City of Portland, Maine - Building or Use Permit Application

Permit No: 03-0360	Issue Date: MAY 29 2003	CBL: 339 D011001
-----------------------	----------------------------	---------------------

Proposed Project Description:
Build 26'x32' single family dwelling

RE: 39 Barclay Avenue – 339-D-011 &012 – R-3 Zone – Permit # 03-0360

Drawing Name: Layout & Utilities Plan
Project: 41 BARCLAY AVENUE, PORTLAND

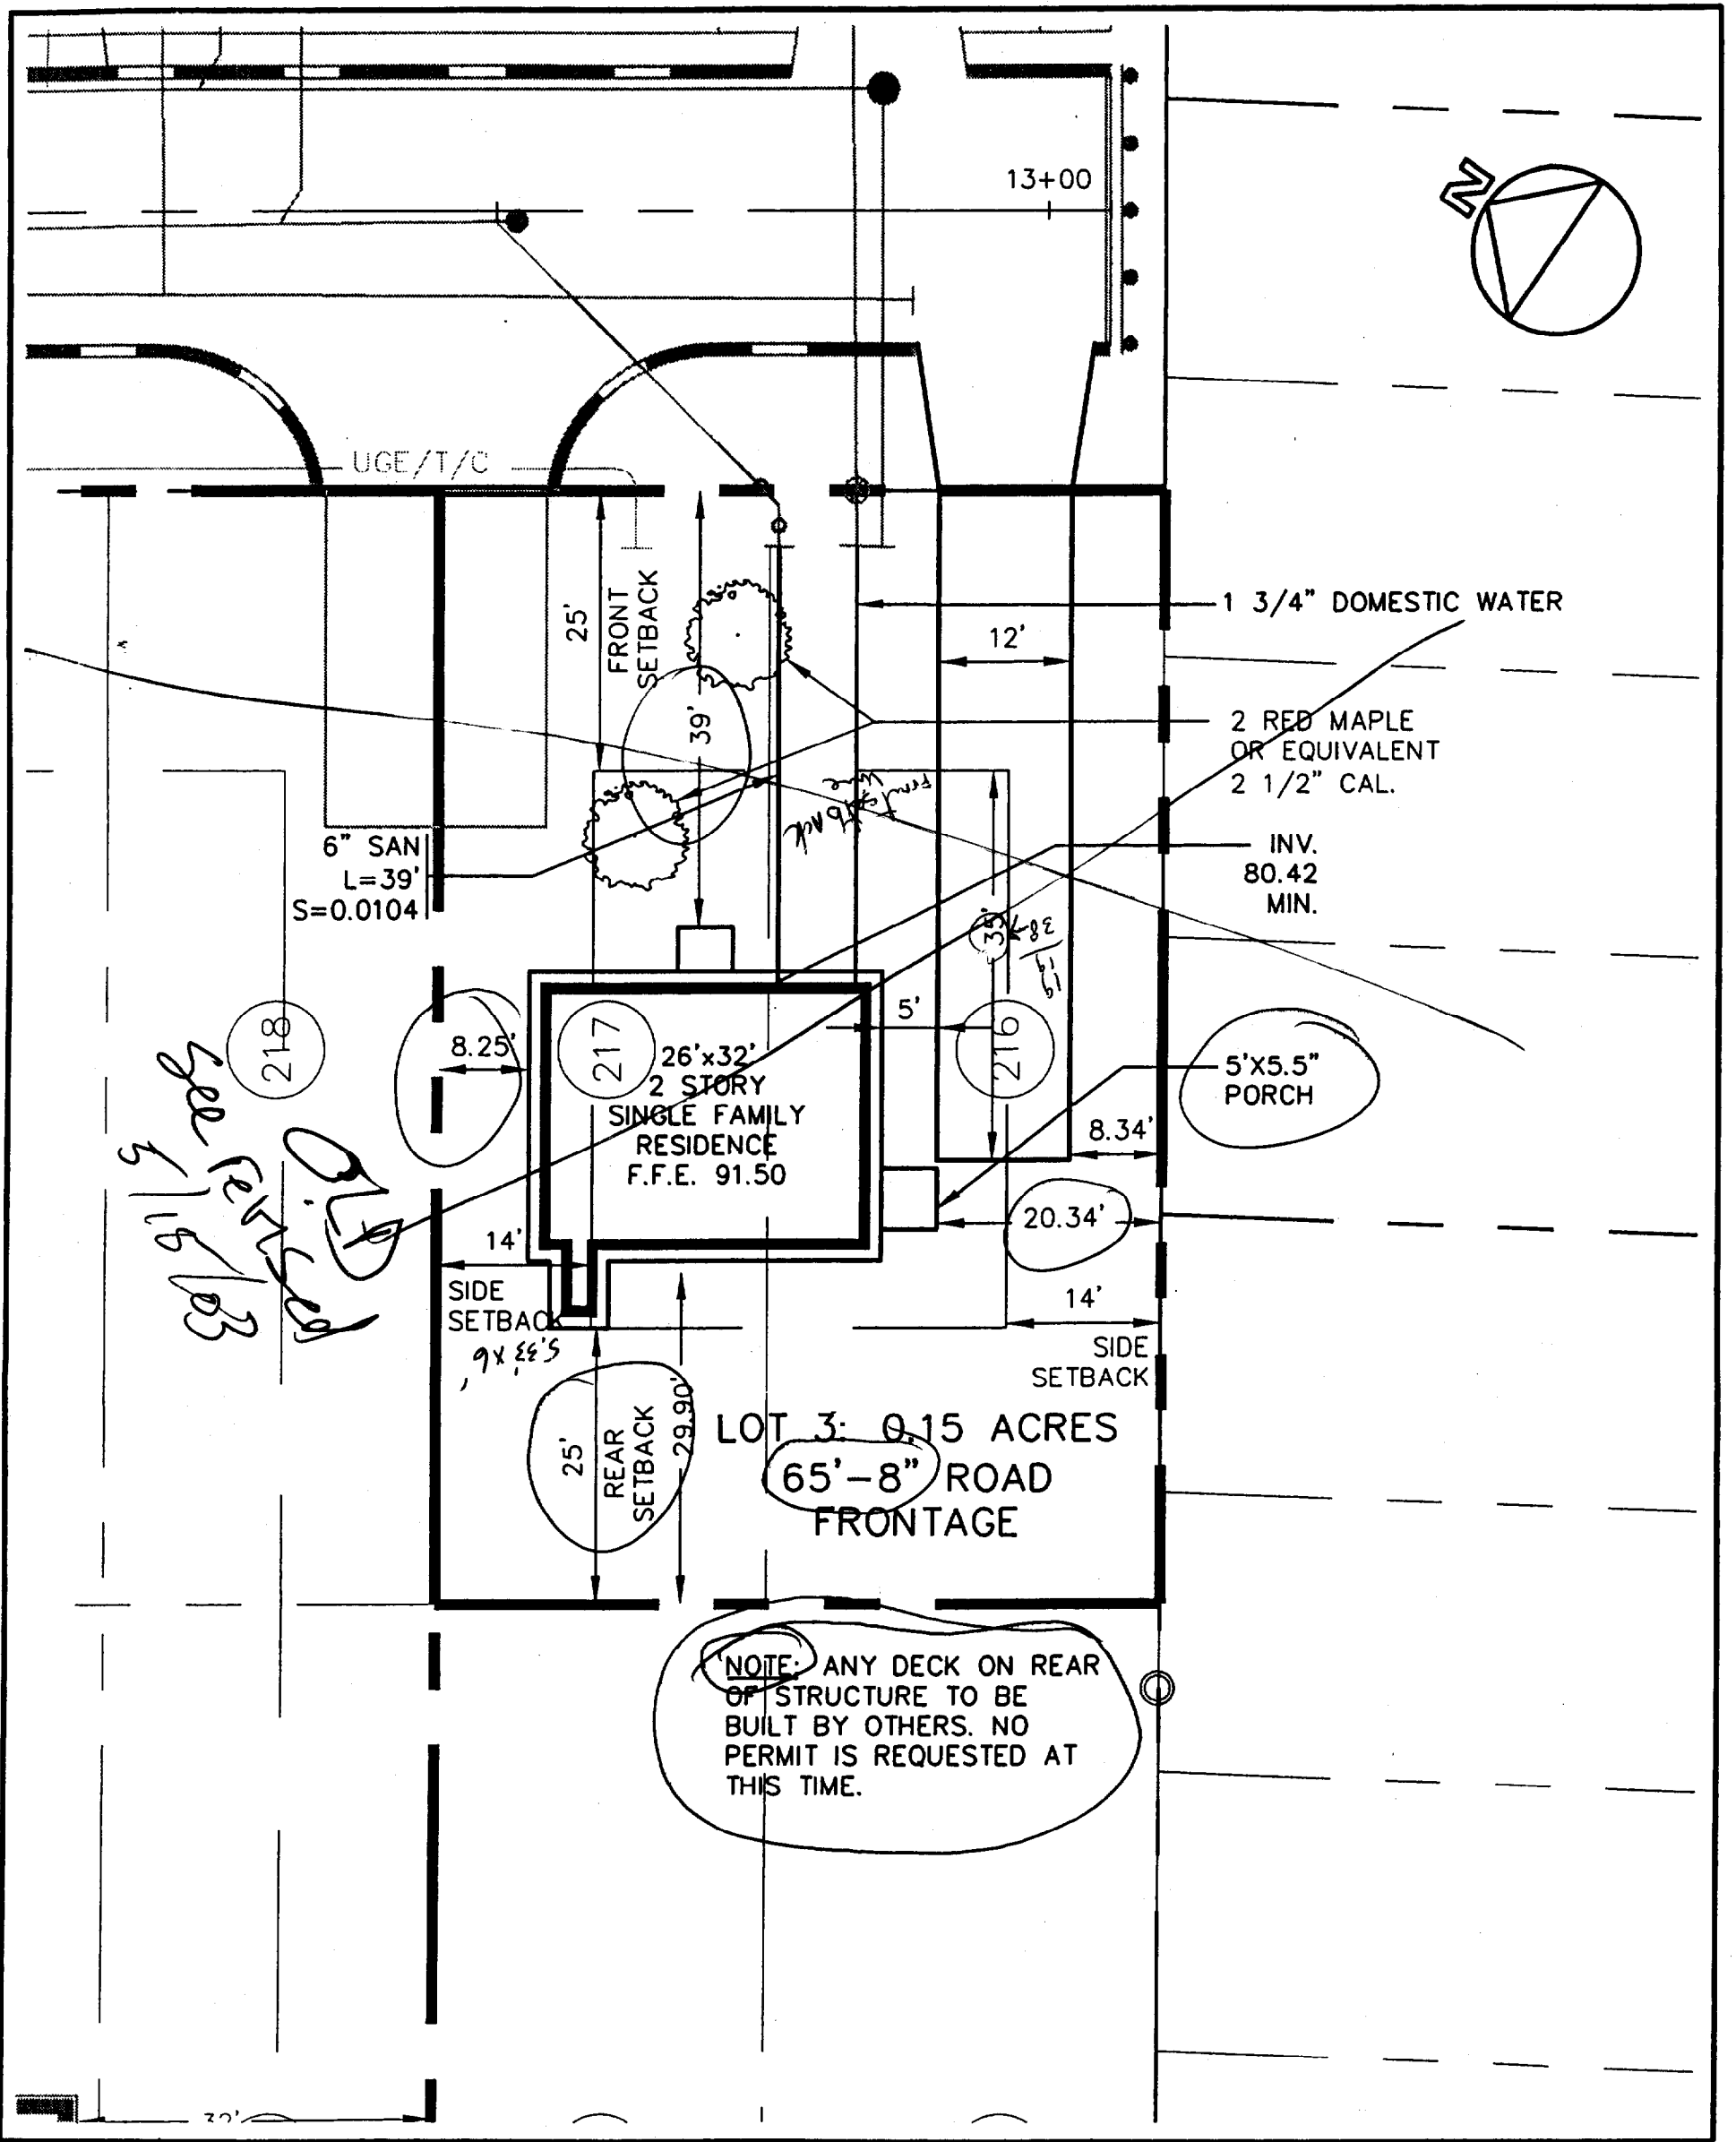
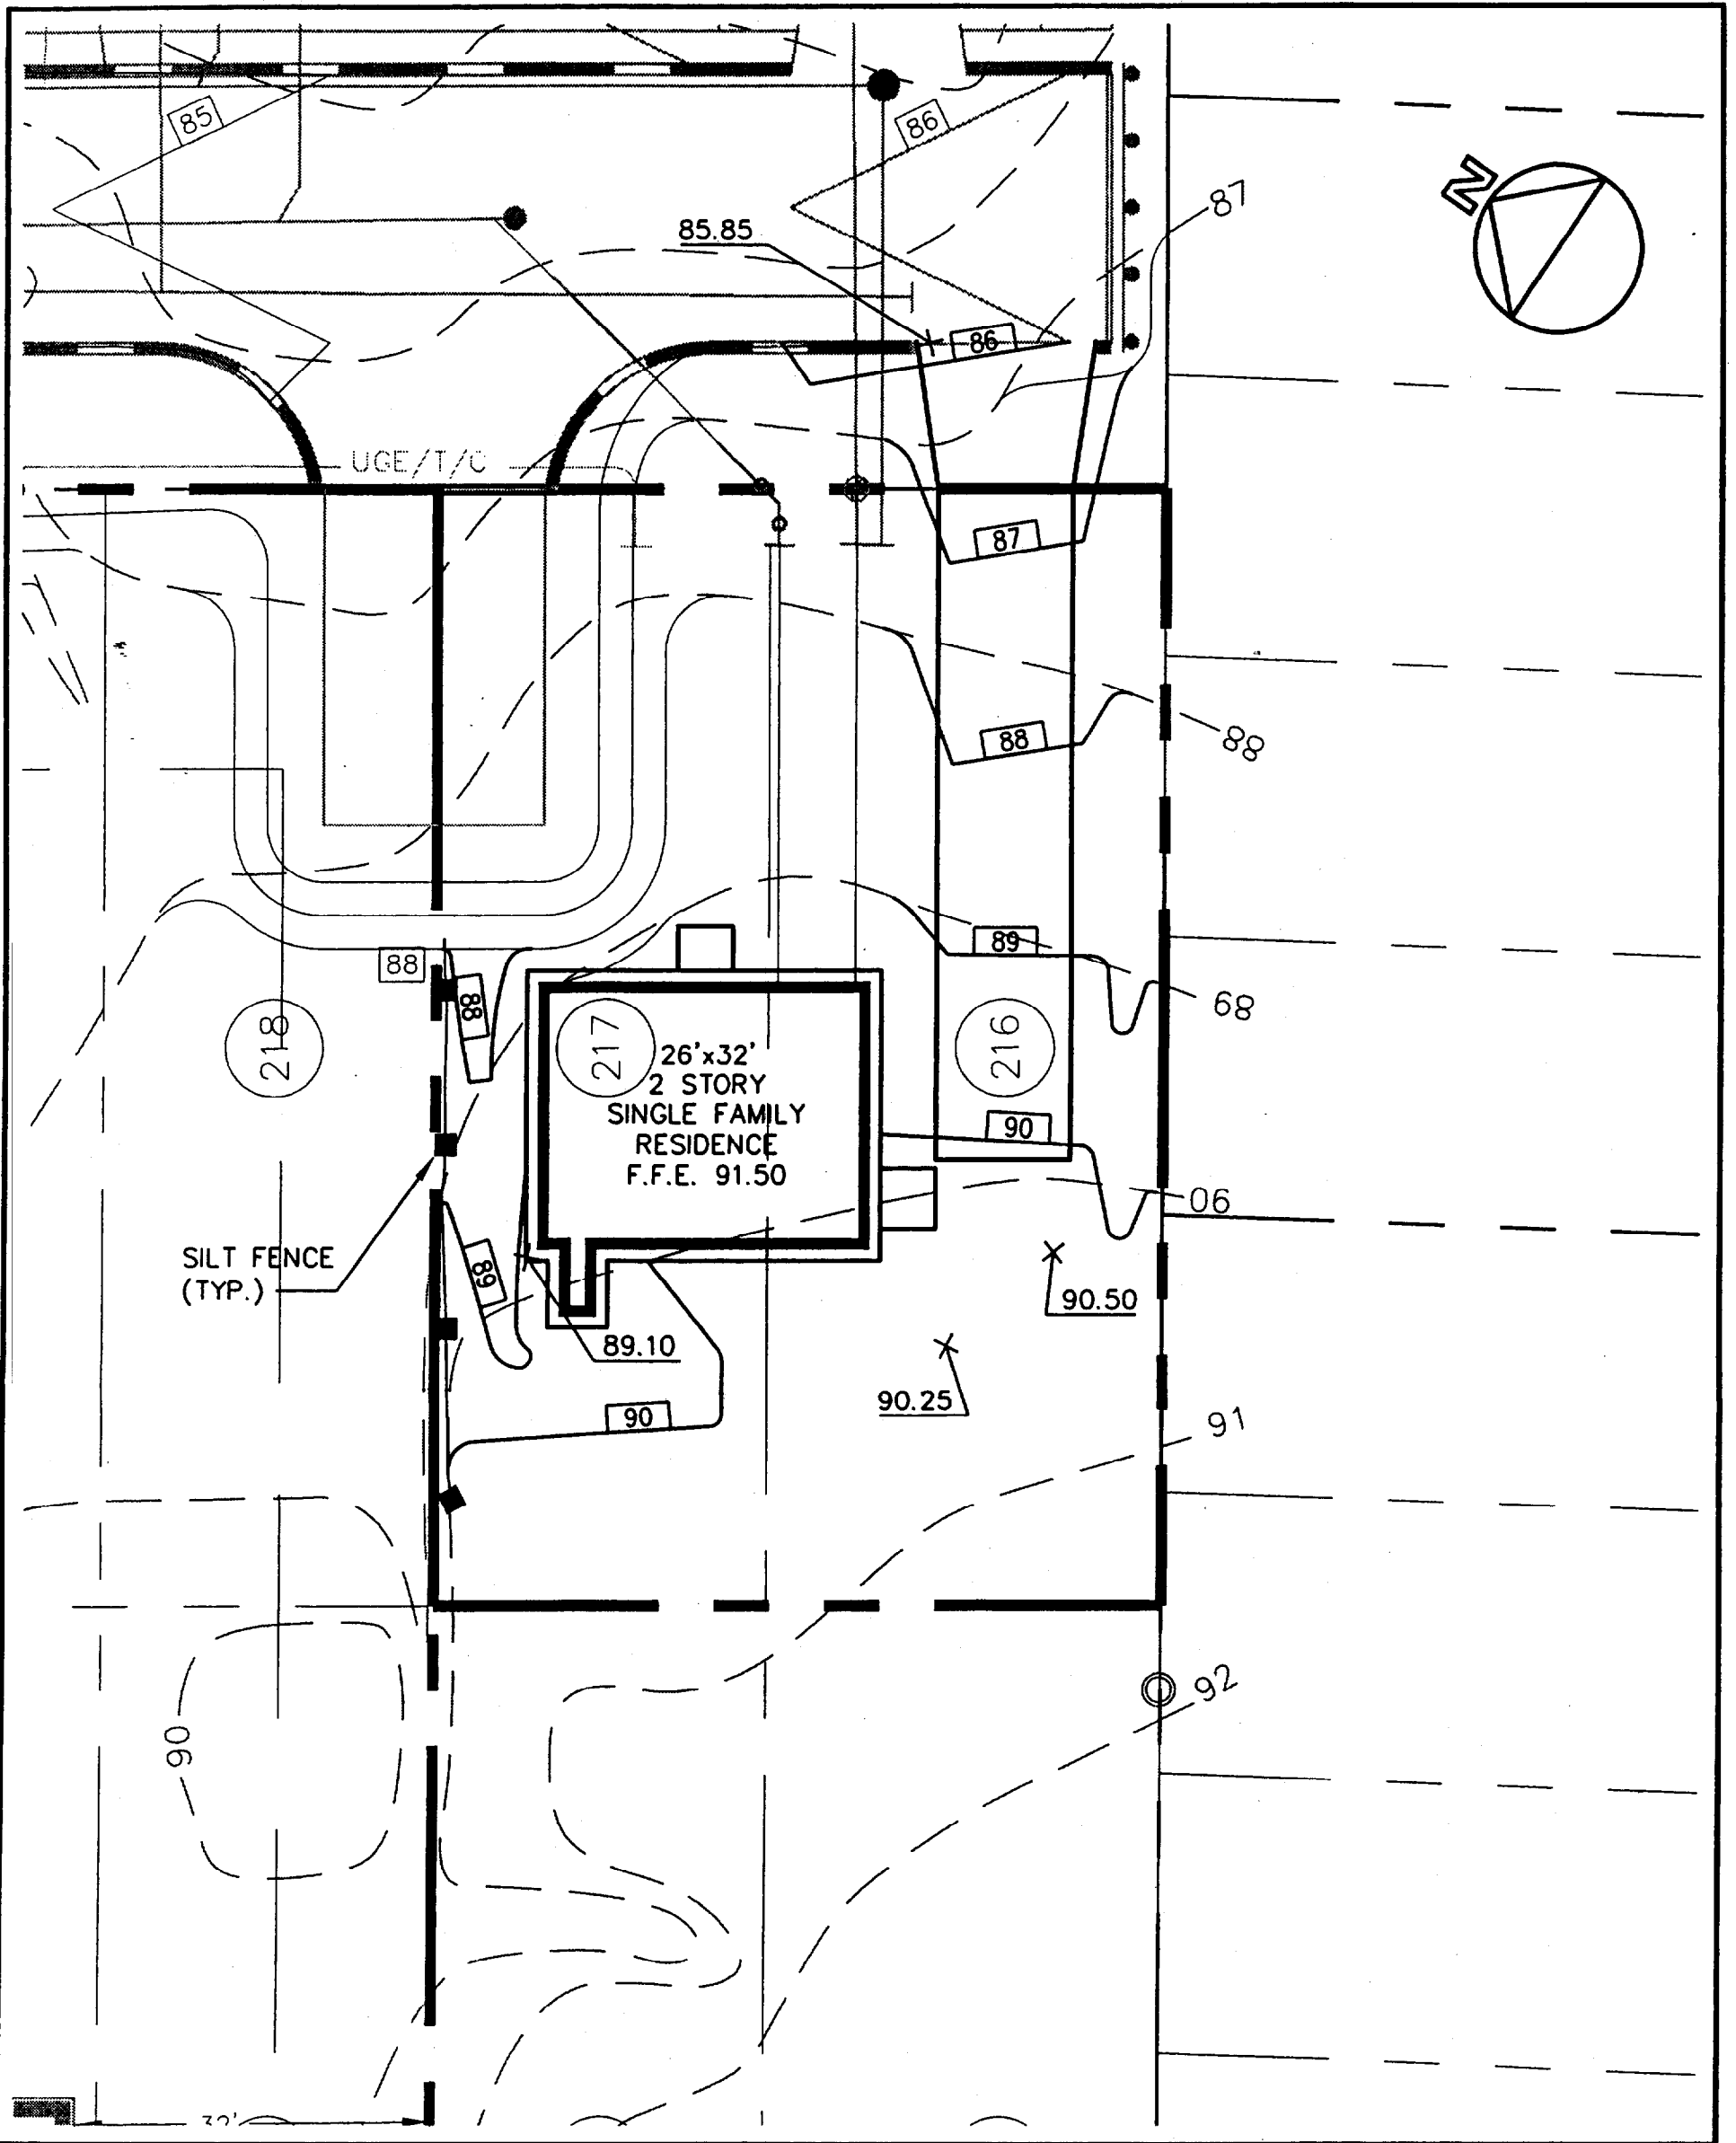
I am in receipt of your permit application to construct a 26' x 32' single family dwelling. Your plans are only showing a parking area of 12' x 35' beyond the front setback line. The standards for a parking space is 9' x 19'. Therefore, two in-line spaces would require a length of 39'. If you revise your plans within 30 days of the date of this letter, I can accept that change as part of this application.

Enclosed please find the revised copies for the above referenced permit showing the changes in parking.
